DECISION DELEGATED TO HEAD OF PLANNING

Application No: H04-0337-26 **Applicant:** Ashwood Homes

Proposal: Erection of 136 dwellings with associated garaging, roads and sewers - Approved under H04-0508-19. Amendment to fenestration to garage frontage of Plot 136

Location: Land Off Town Dam Lane Donington Spalding

DRAWING TITLE:
DOUBLE GARAGE

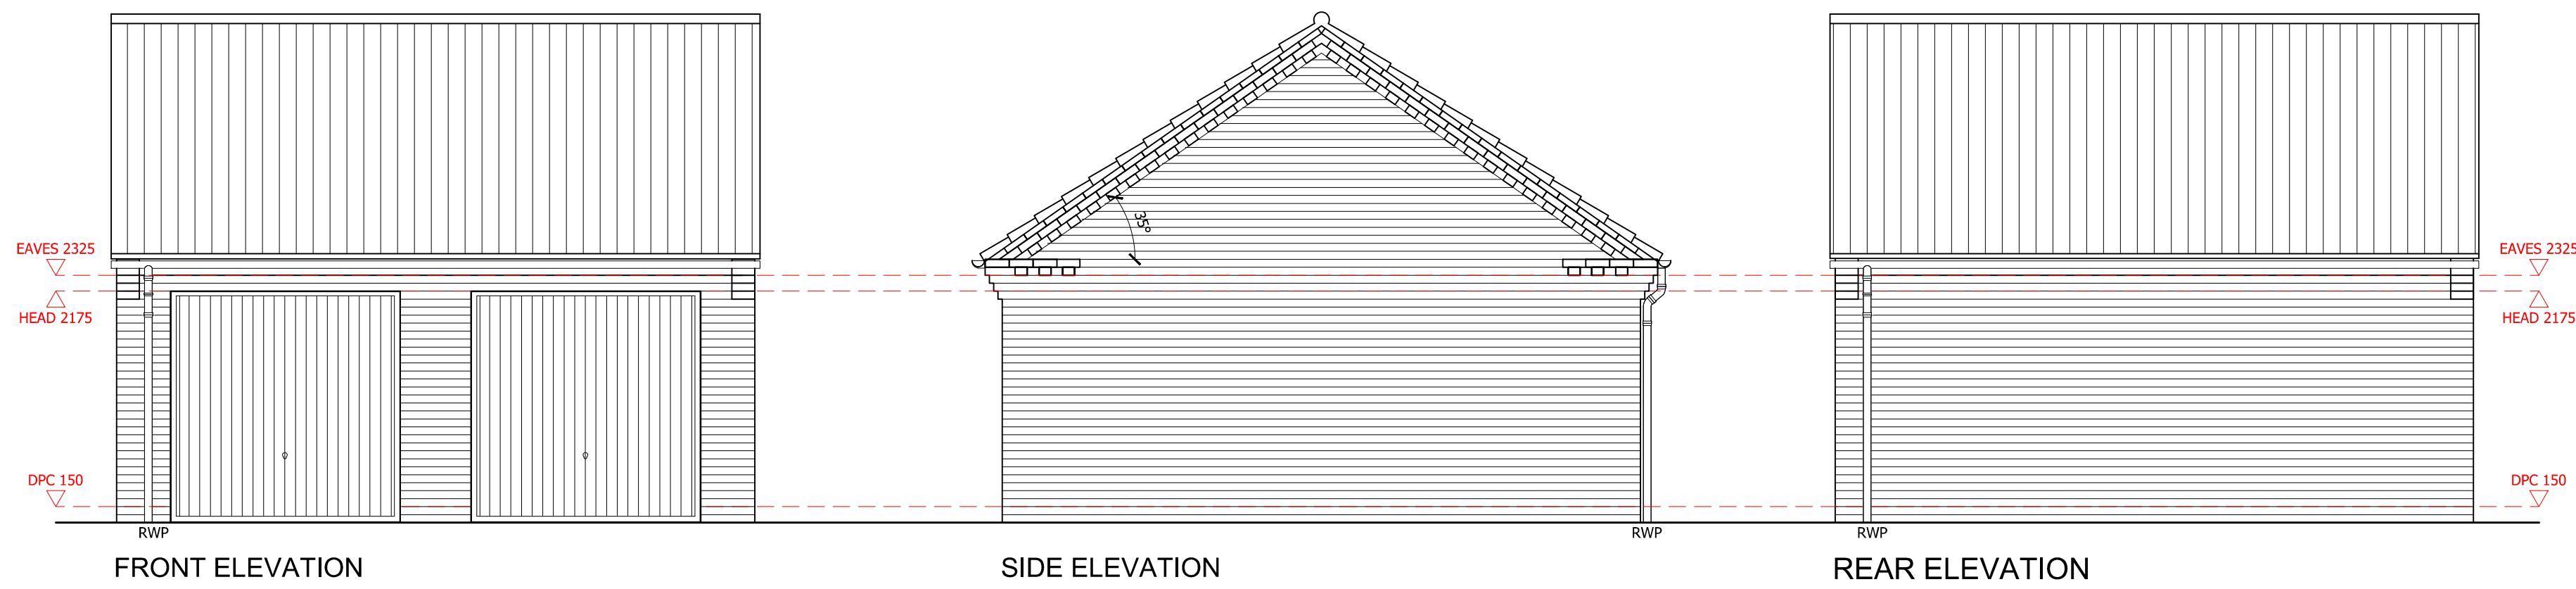
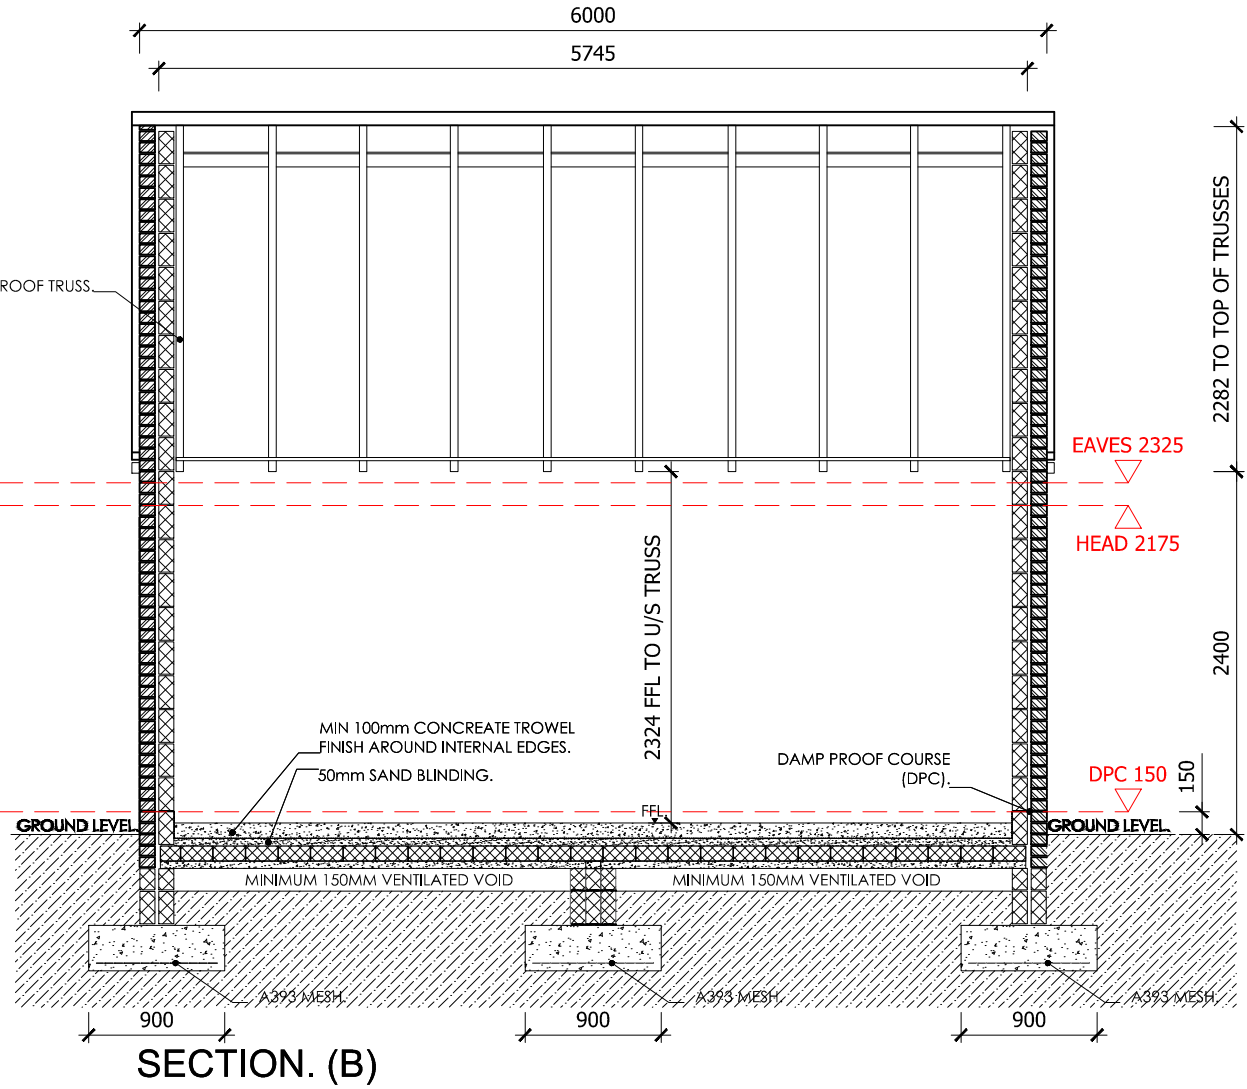
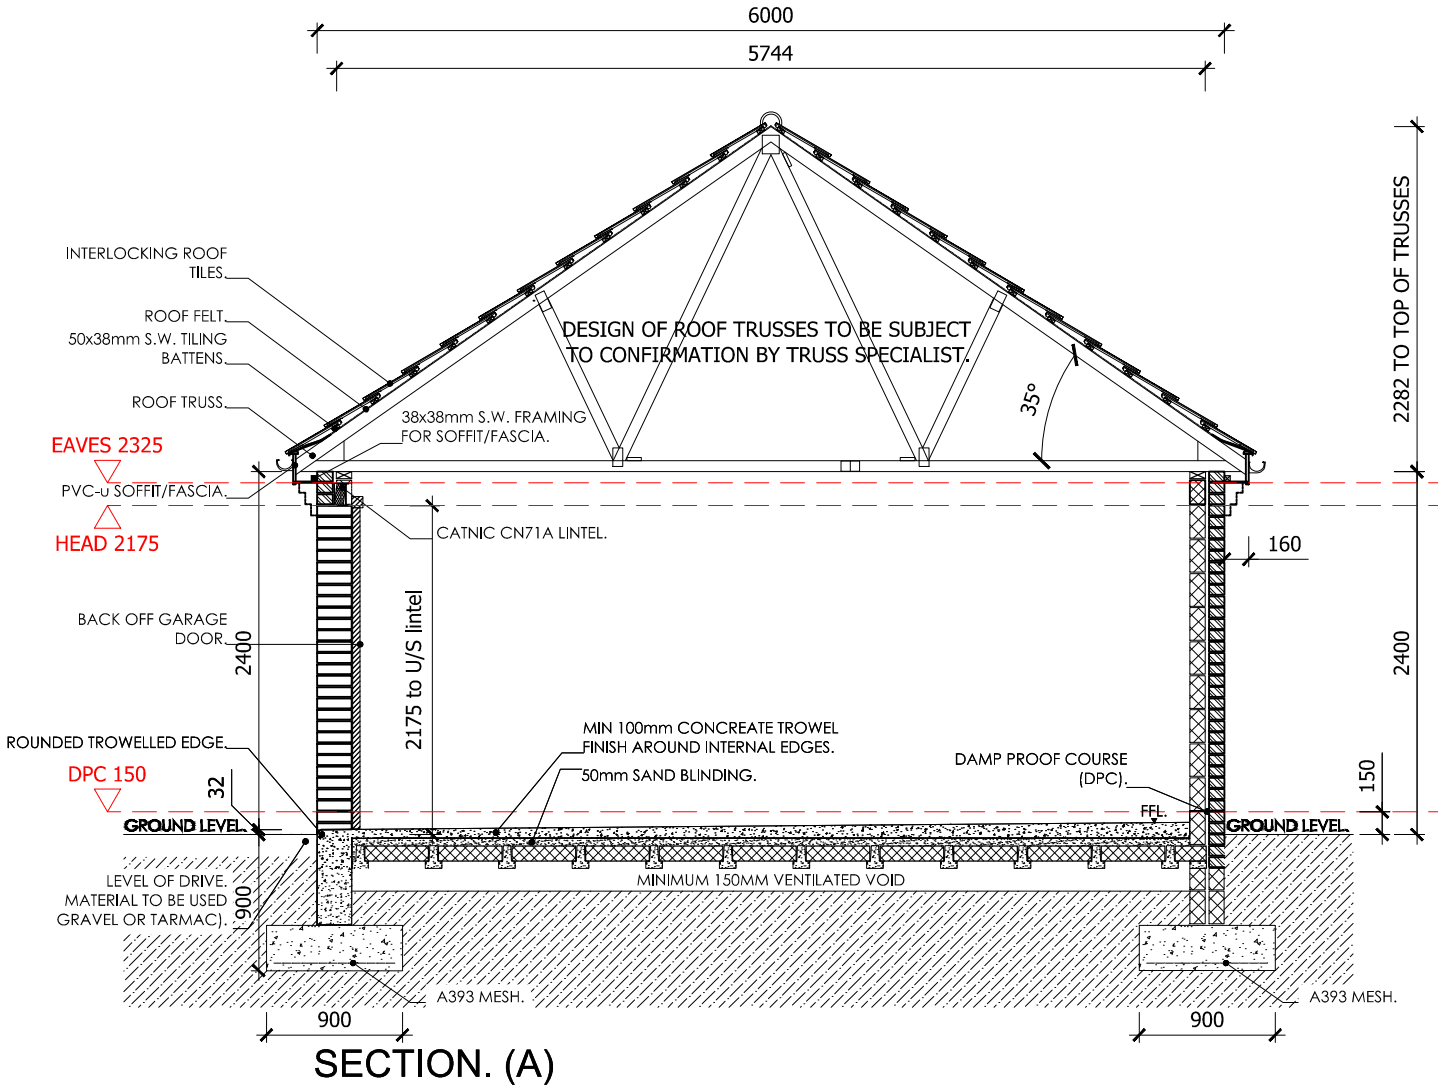
Under permission H04-0508-19, the approved double garages feature two garage doors on their front elevations and no other windows or doors. The garages measure 6m by 6m, and 4.75m in height up to their ridgelines.

1 Goodison Road, Lincs Gateway Business Park, Spalding, Lincs, PE12 6FY T: 01406 490590	HOUSE TYPE: Double Garage Side Pitched - Plot 136
	DRAWING TITLE: DESIGN SHEET
	DRAWING NUMBER: DG - DS - 001

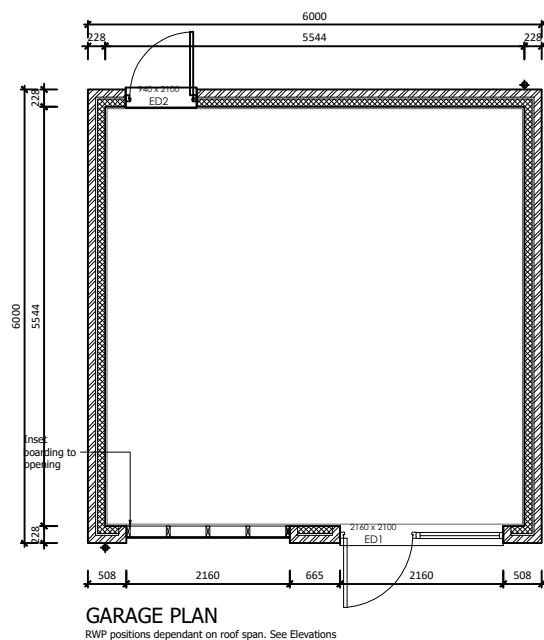
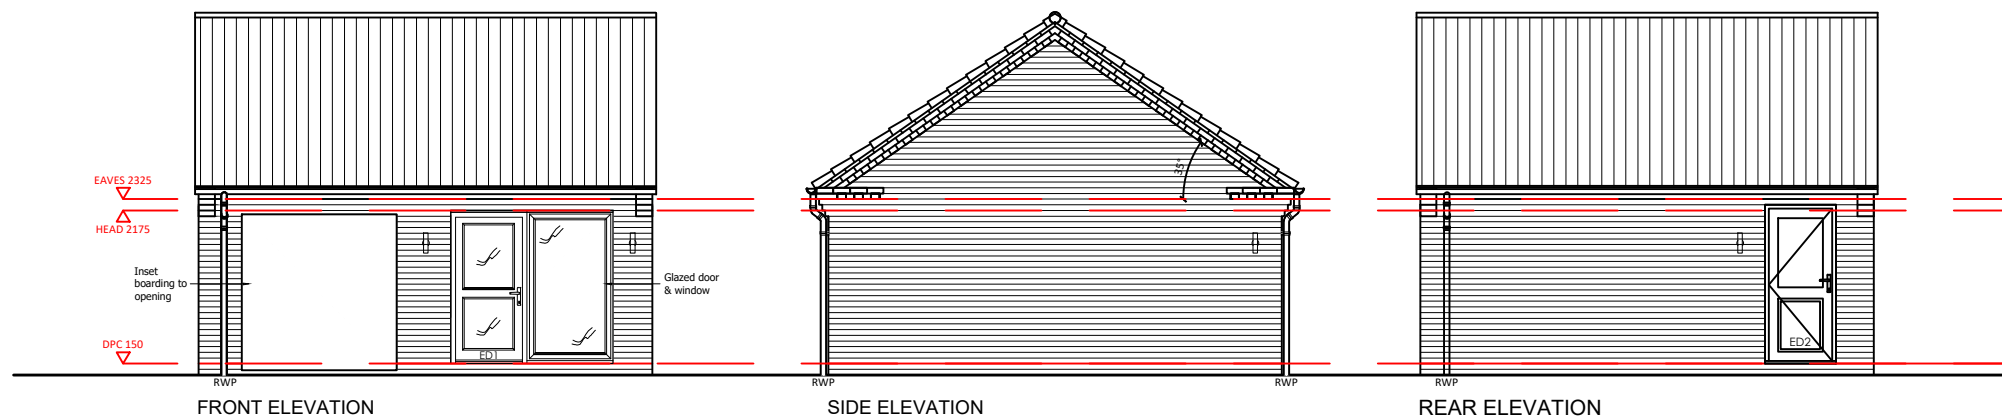
Under the current application, the garage for plot 136 (104 Town Dam Lane) is proposed to feature a glazed door and a window in place of one of the approved garage doors. A doorway is also proposed on the rear elevation. No changes are proposed on the side elevations of the garage and the dimensions of the garage would remain unchanged. It is considered that the changes to the front and rear elevations are acceptable in terms of their visual impact. The changes would not significantly alter the character and appearance of the building.

The proposed amendments would not cause an adverse impact to the character or appearance of the area. Therefore, the proposed amendments accord with Policies 2 and 3 of the Local Plan and Section 12 of the NPPF.
